05 August 2020

Our Ref: L.S20352.002.docx

## RE: 28 McPHERSON STREET, BANKSMEADOW 2019 – RESPONSE TO SUBMISSIONS ON FLOODING ISSUES

5-1

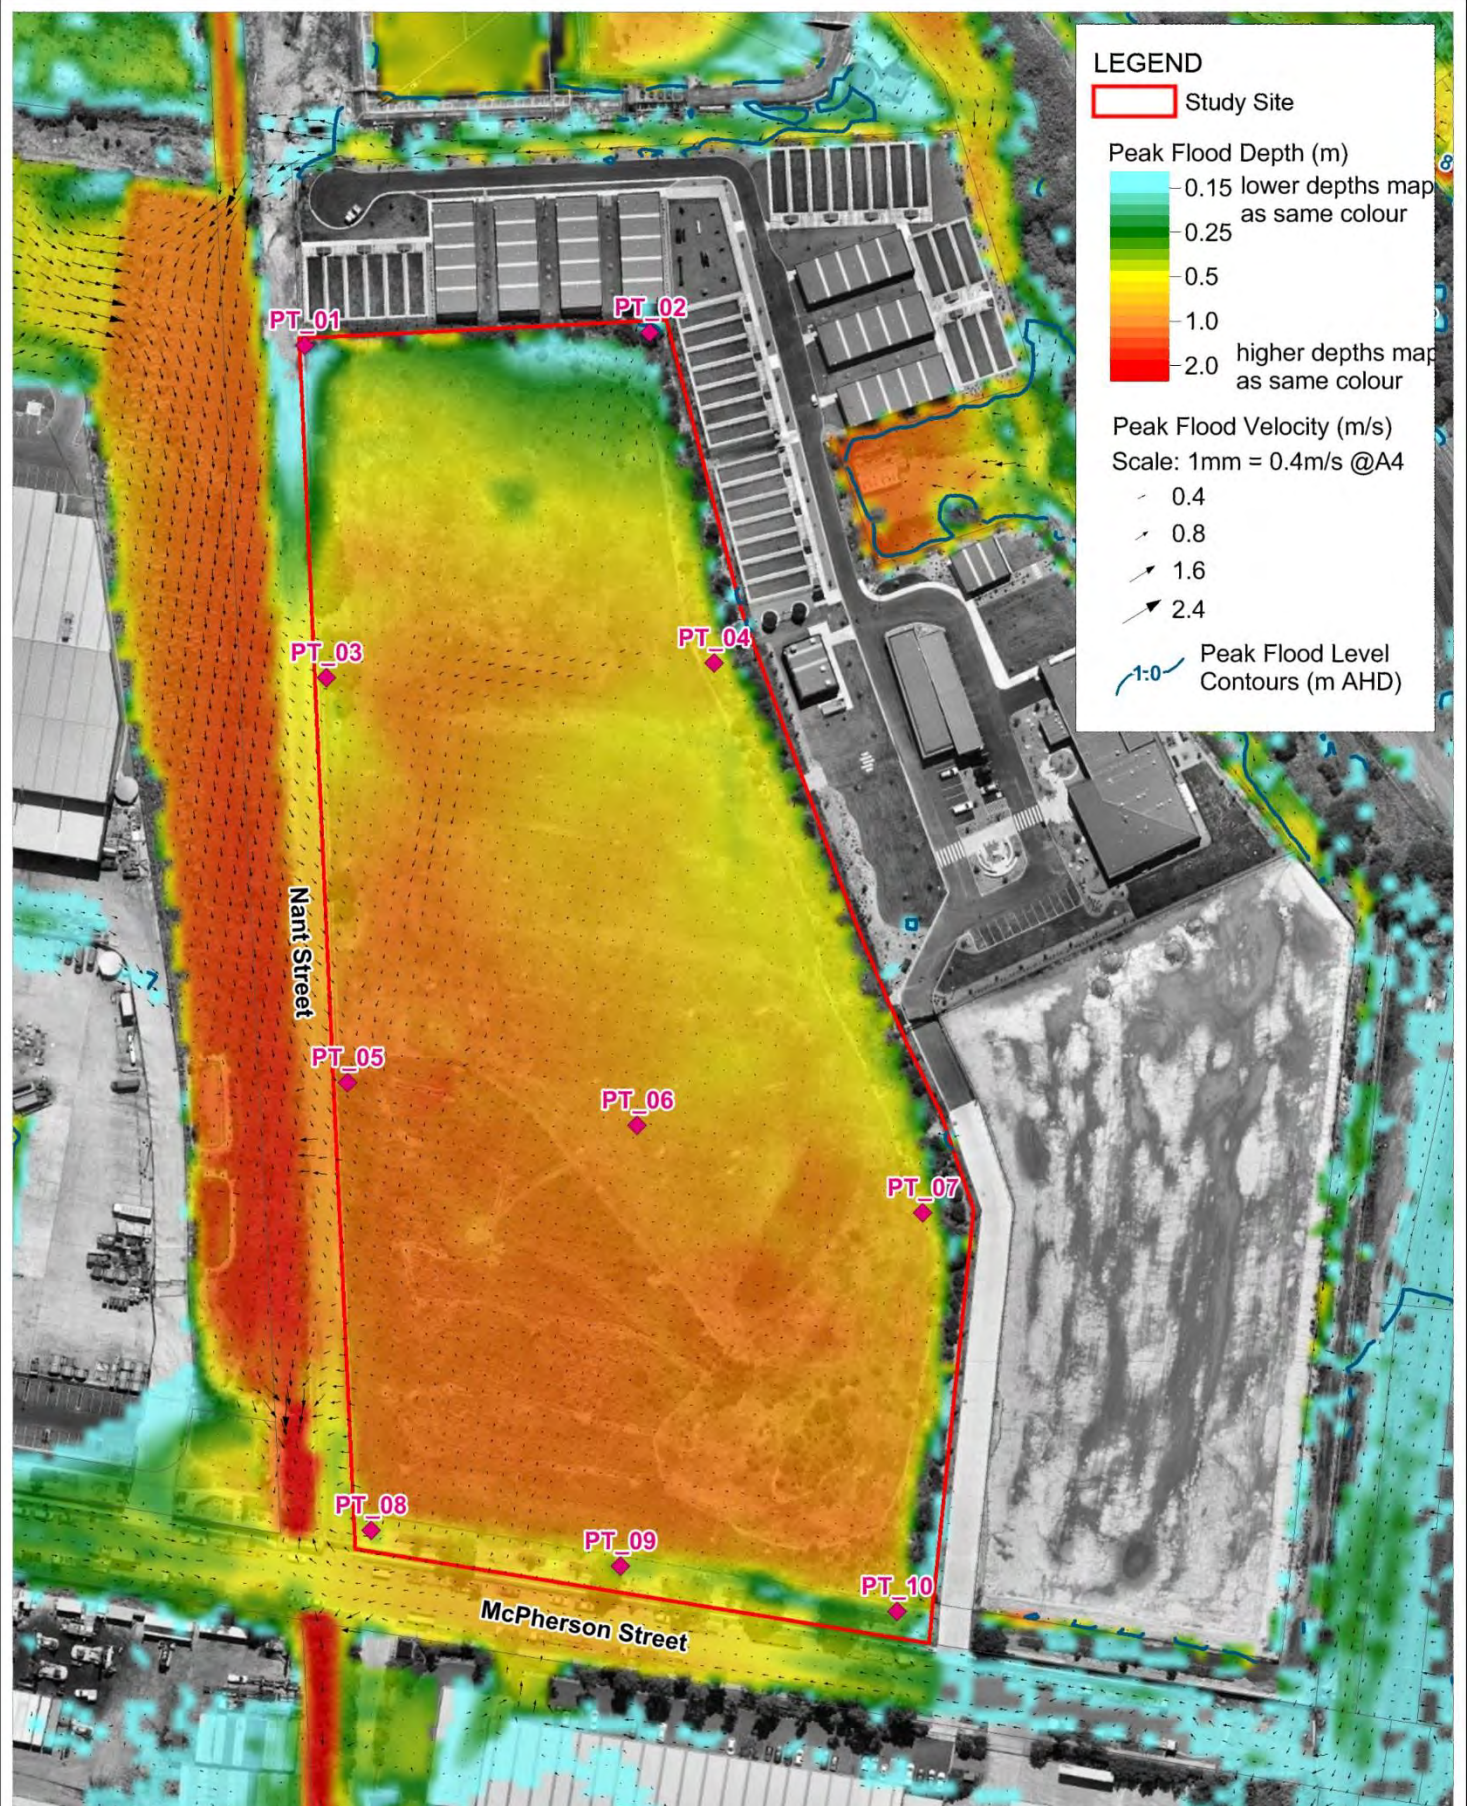
• Council notes that the majority of flood modelling locations for the proposed development are shown around the perimeter of the site and only one is located in the centre of the site where the flood levels are deepest. Council queries the adequacy of the modelling in relation to the impact on the existing peak water depths and velocities at the site an in relation to the criteria for the extent of the surrounding area that will be impacted by flooding as a result of the proposed development.	This query has been interpreted as the flood level reporting locations identified in Figure 5-1 and the corresponding tables of peak flood level and velocity. The hydraulic parameters within the flood storage area are relatively uniform. Peak water levels are the same across the storage area as there are downstream hydraulic controls (overtopping of McPherson Street and the downstream channel constriction on the Toll Intermodal site) which provide a backwater influence across the site. Whilst there is some variation in peak velocities, they are all relatively low given the flood storage function of Lot 9 rather than a highly convective flow region. Alternative points of reporting would not identify any substantially different result. Additional flood mapping is attached as Figure A1 and A2 which covers a broader area downstream of the site to the outlet of Springvale Drain into Botany Bay. The existing (pre-development) 1% AEP flood inundation extent and peak flood depth distribution is shown in Figure A-1. A similar extent for the flood level impact map for the proposed development is shown in Figure A-2.
